Our ref: AN/2024/135611/02-
L01

Date: 06 November 2024

Order Granting Development Consent for the Tillbridge Solar Project (EN010142) - Written representations submission.

FIGURE TITLE
Watercourses, Flood Zones and Internal Drainage Boards (Sheet 1 of 3)

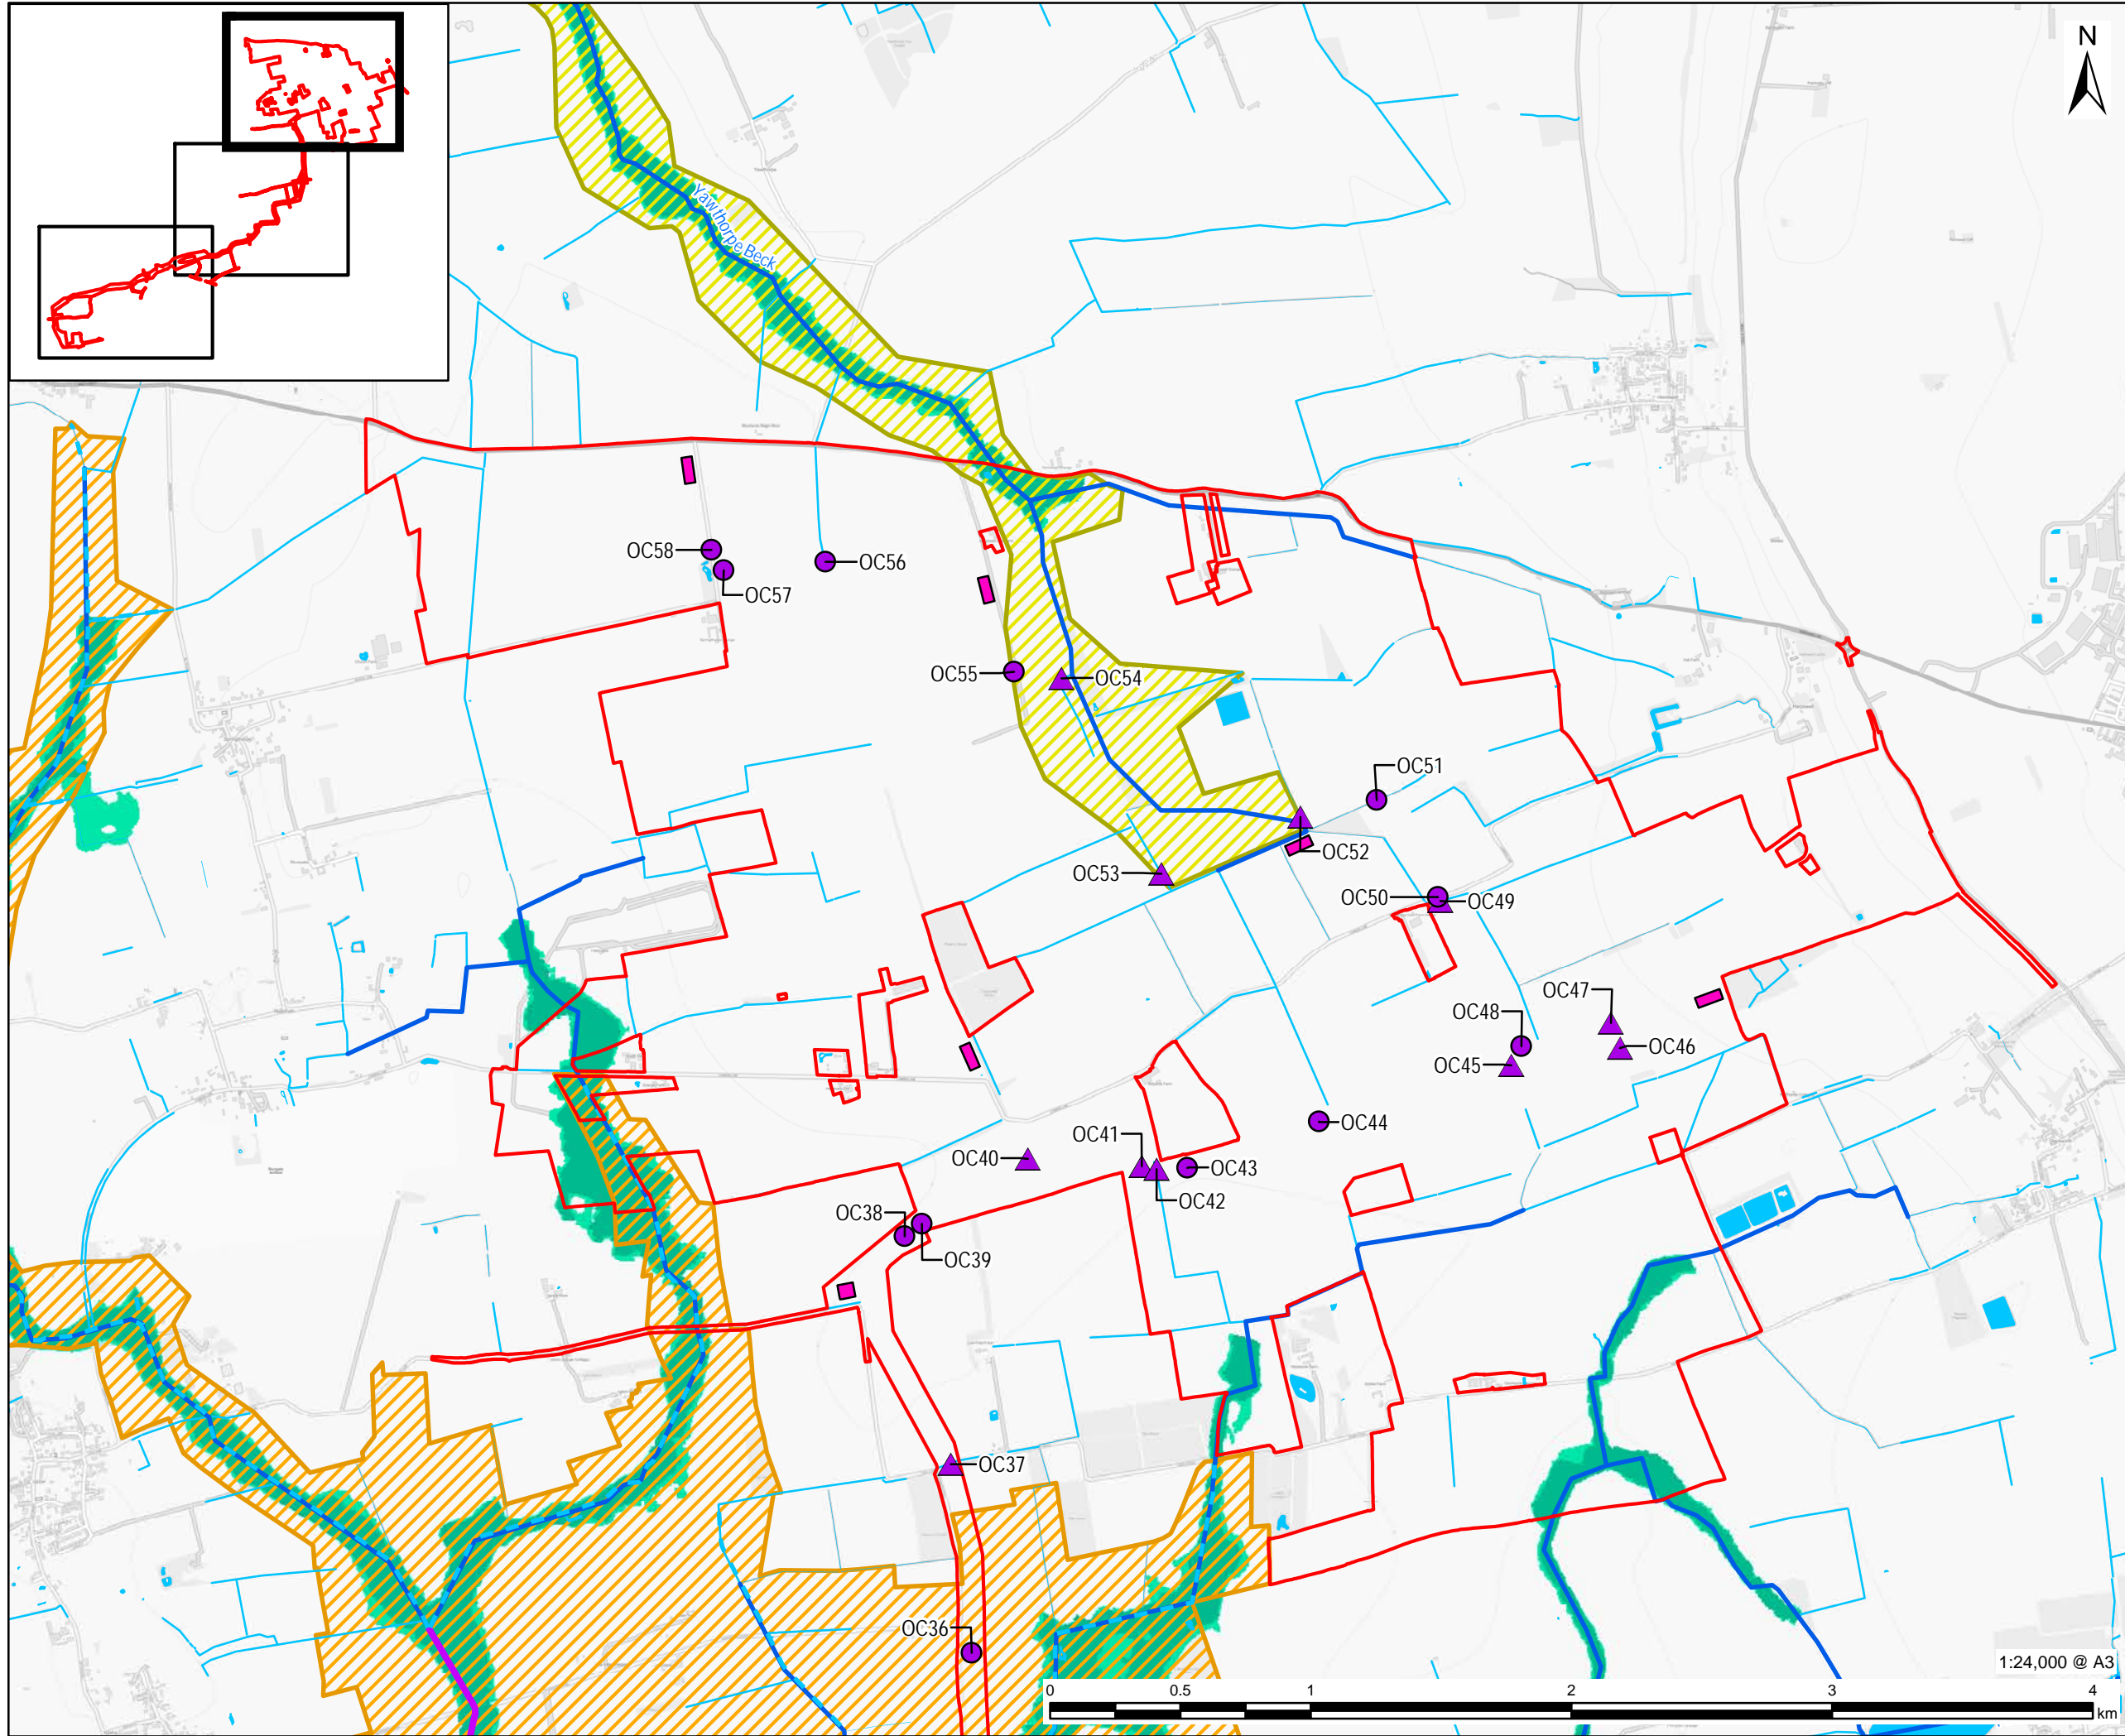
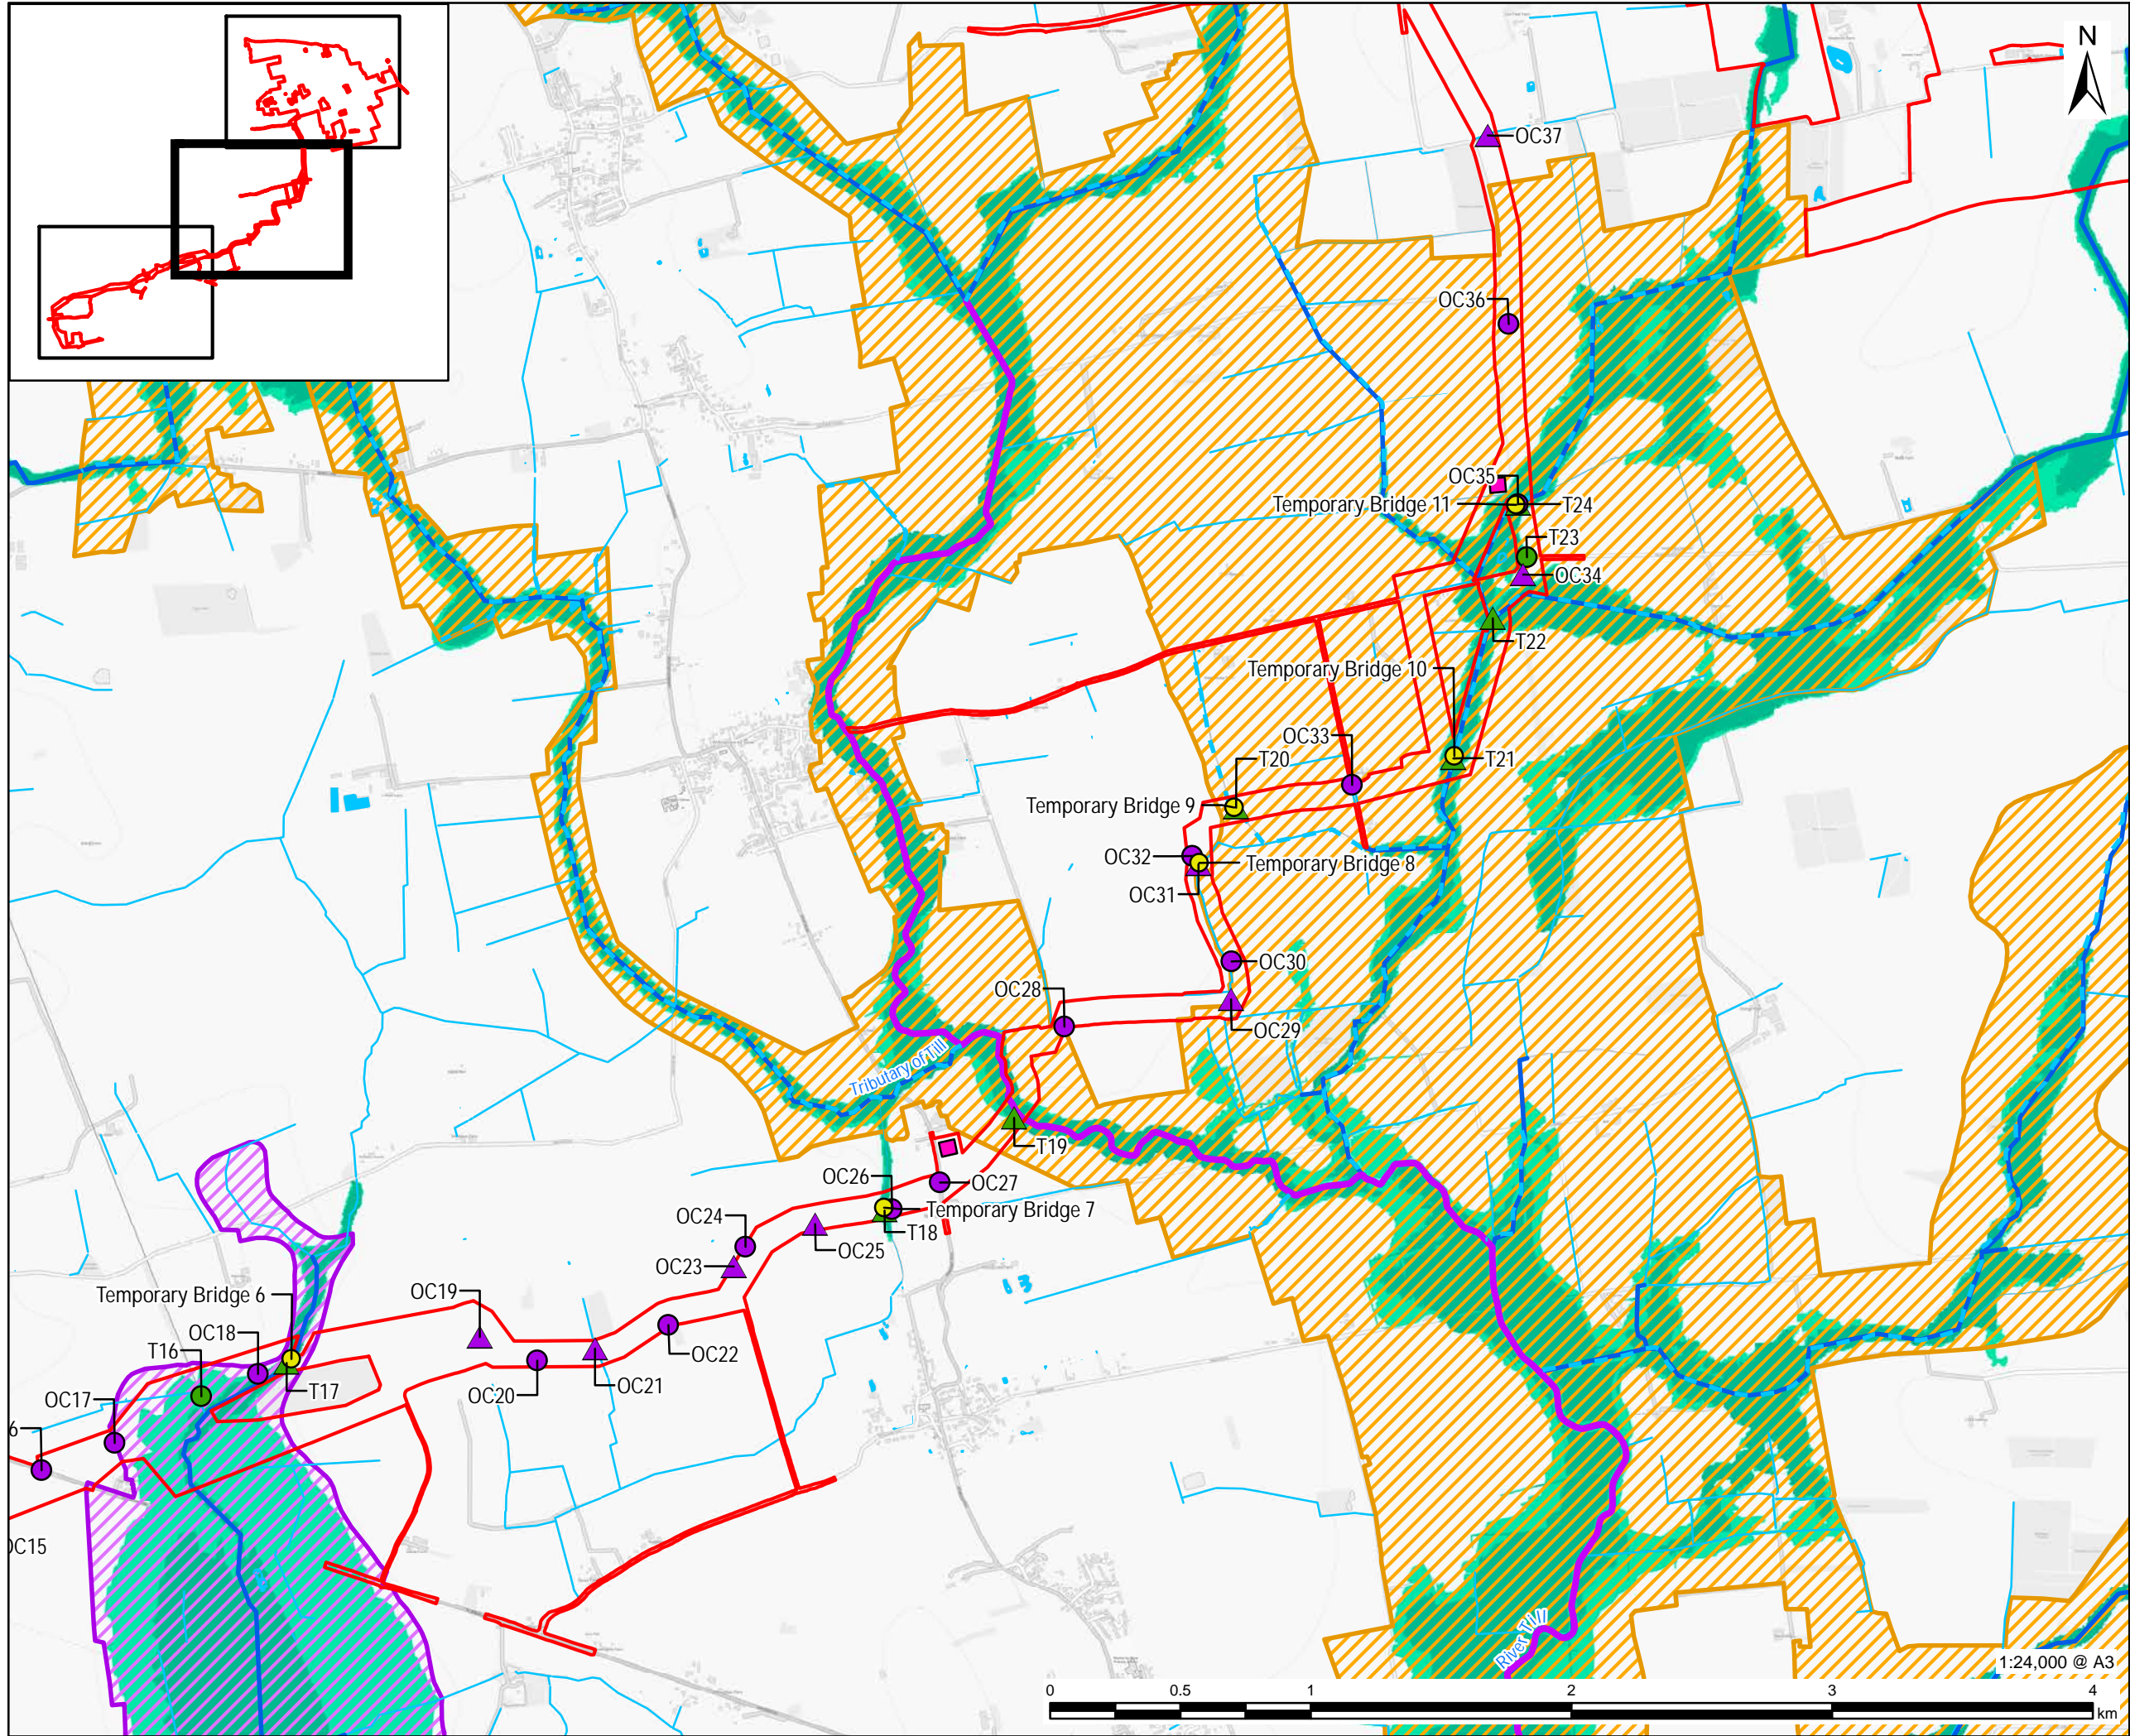
4.5 In addition, in paragraph 4.5 of our Relevant Representations, we referred to 2 temporary construction compounds being within Flood Zone 3 and asked for the situation in relation to these to be looked into further by the applicants. They have now done this and submitted to us a Technical Note prepared by AECOM. The applicants have advised they intend to submit this at Deadline 2.

4.7 In the light of the above, we are aware of Section 8.1.2 in the appendix 10-3 Flood Risk Assessment with document reference EN010142/APP/6.2 which says 'No additional flood risk mitigation or floodplain compensation is required for the scheme to be compliant with flood risk policy and guidance'. This will need amending to reflect the need for the works described in the Planning Condition asked for above.

4.9 According to Environment Agency modelling, during a breach of defences flood event on the River Trent, flood heights at the site could reach up to 7.33mAOD. The flood warning and emergency response situation therefore needs to be considered.

4.6 We have considered this document and, provided it is submitted to you in the form we have seen, can advise that the proposed development will only meet the National Planning Policy Framework's requirements in relation to flood risk if the following Planning Condition is included within the Development Consent Order:

The development shall be carried out in accordance with the submitted technical note (6.2 Appendix 10-3 Annex F Technical Note 24-10-14, AECOM, 17 October 2024) and the following mitigation measures it details:

- A safe refuge shall be provided at both the North and South temporary construction compounds with finished floor levels no lower than 7.66mAOD
- The Emergency Response Plan for the site will include a requirement for the appropriate persons to sign up to the Environment Agency's flood warning service and will include details of the evacuation plans for the site on receipt of a flood warning.
